Our Ref: A/54/20/HH

**Town & Country Planning Act 1990 (as amended)
Town & Country Planning (Development Management Procedure) (England) Order 2015
Application for Planning Permission for Works or Extension to a Dwelling**

Development Proposed conversion and extension to existing garage into ancillary accommodation, new driveway to front of property
Location Ariston Water Lane Angmering

HAPA ARCHITECTS			
Job Name			
Ariston, Water Lane, Angmering, Littlehampton			
Status	PLANNING	Drawing Type	PROPOSED SITE PLAN/ BLOCK AND PROPOSED GARAGE CONVERSION PLAN AND ELEVATIONS
Date	APRIL '20	Scale	1:50, 100 & 500 @ A1
Job Ref			WL_101
Drawing Number			L-200a

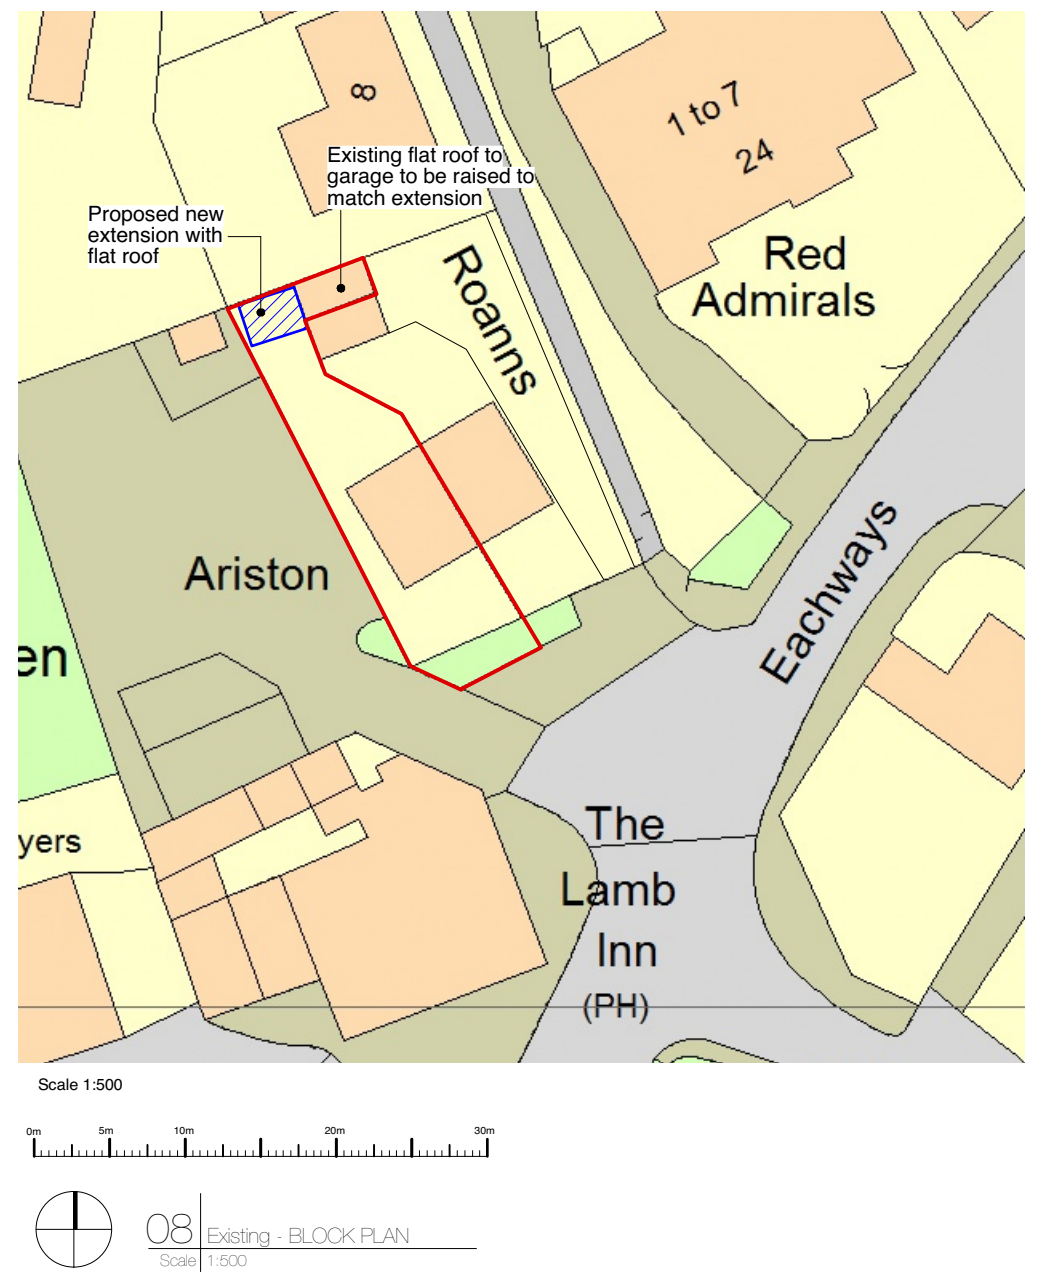
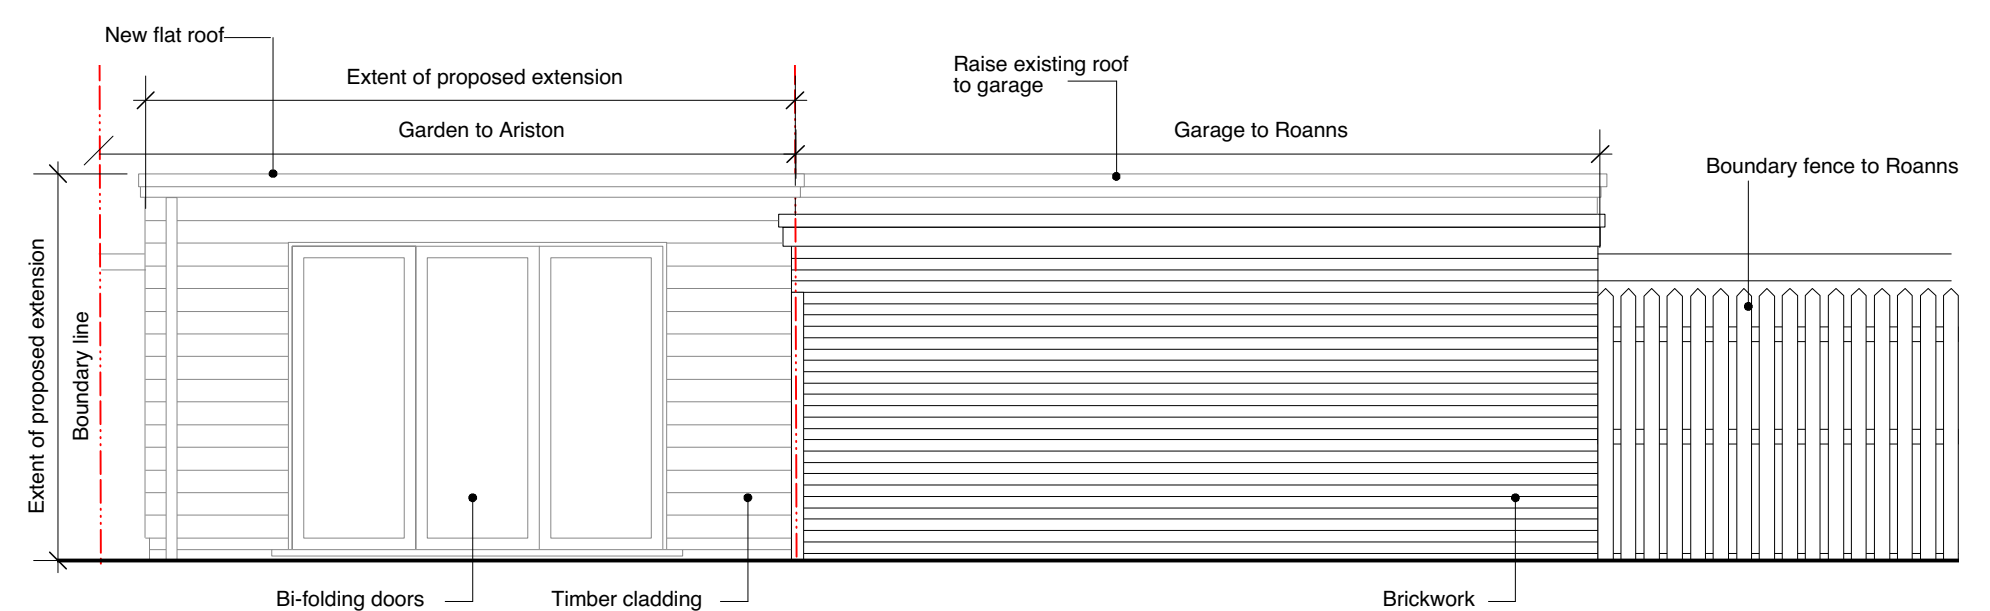
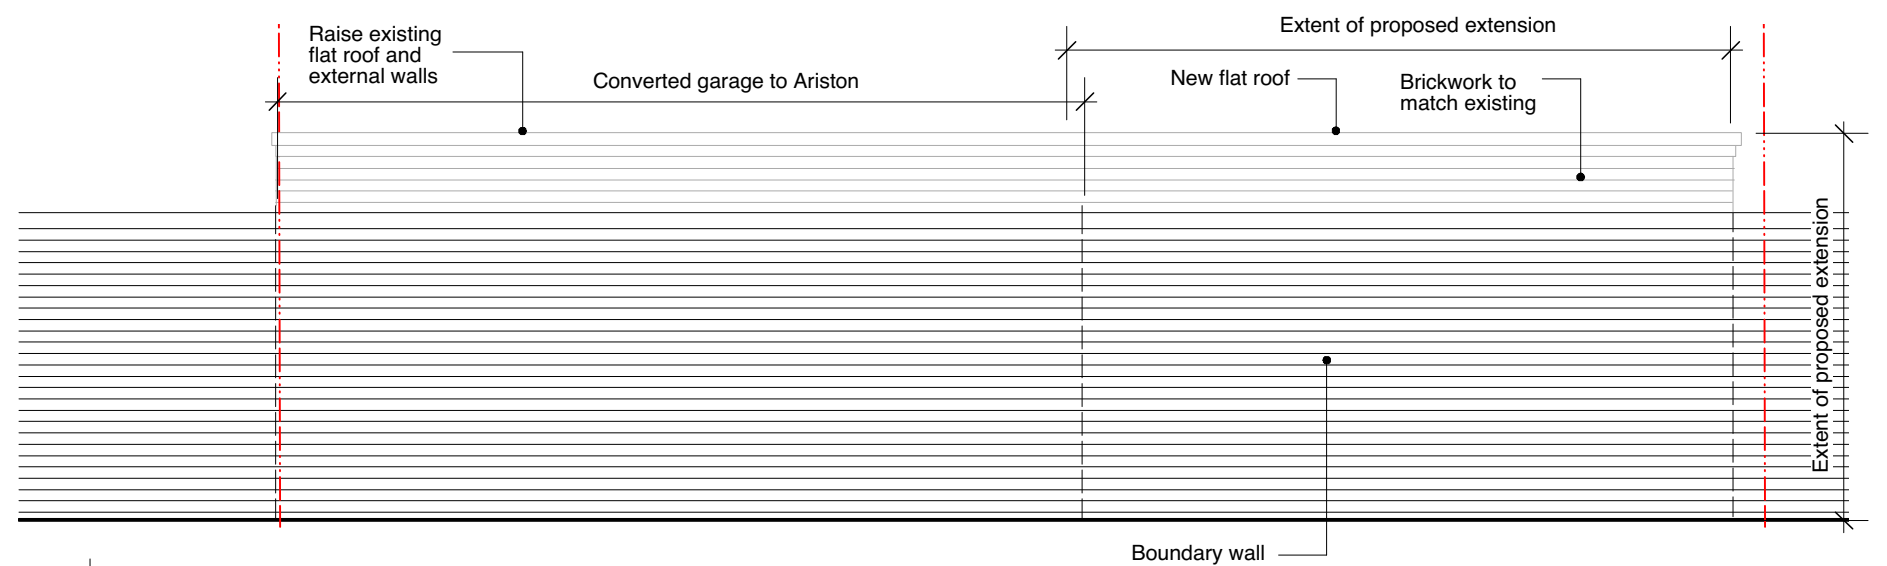
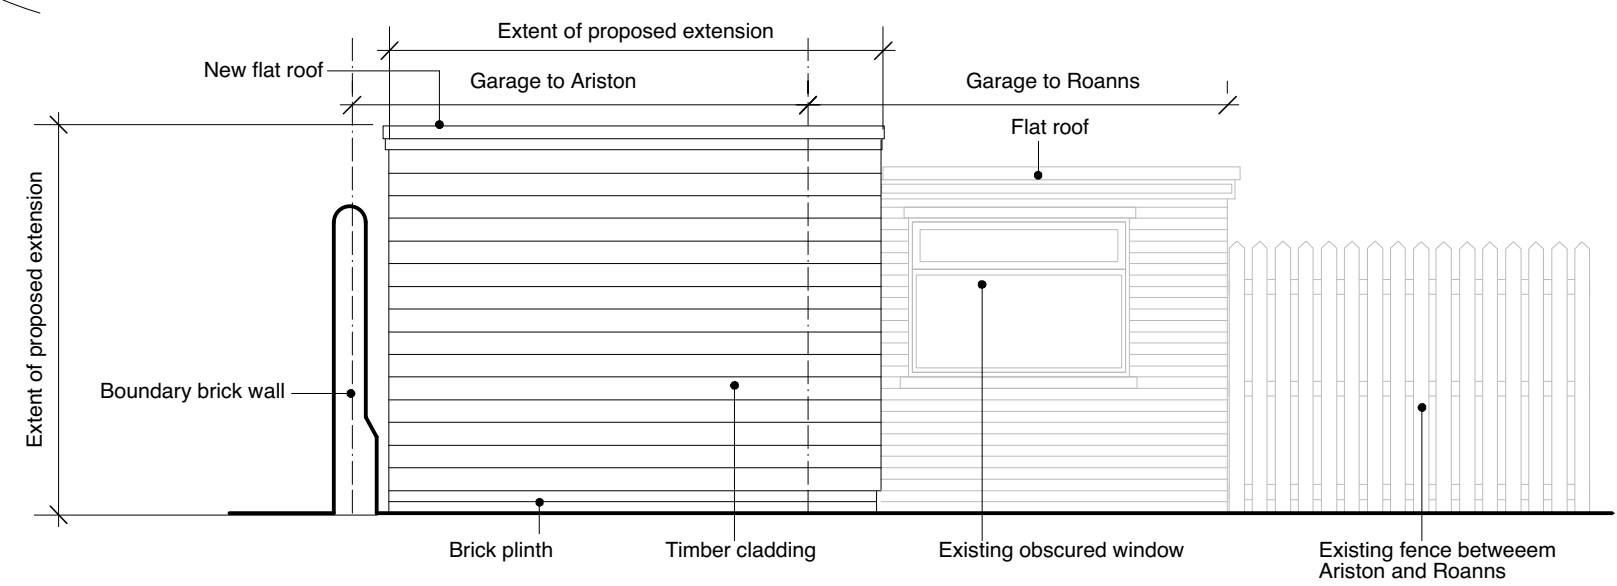
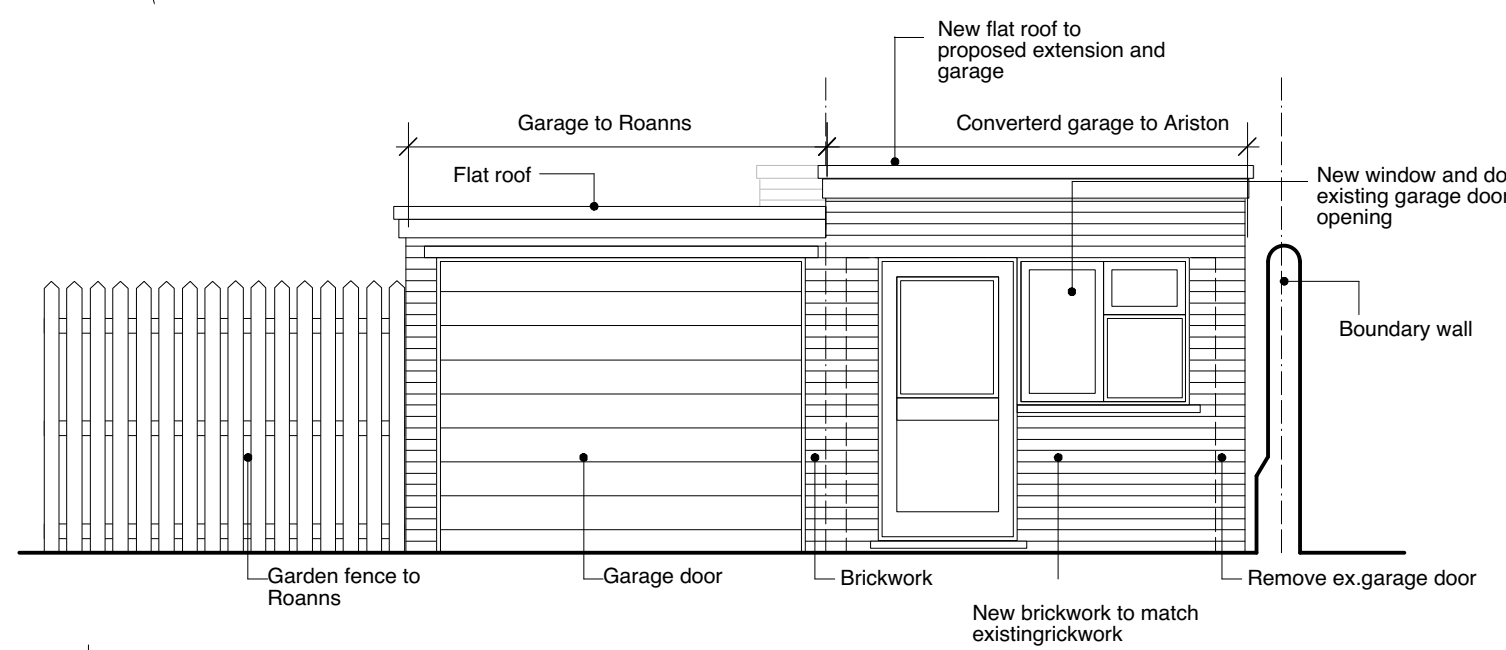
Room Labels: You are required to have room labels on all your floor plans.

Dimensions: You are required to have dimensions on the block plan from the proposed extension to all site boundaries.
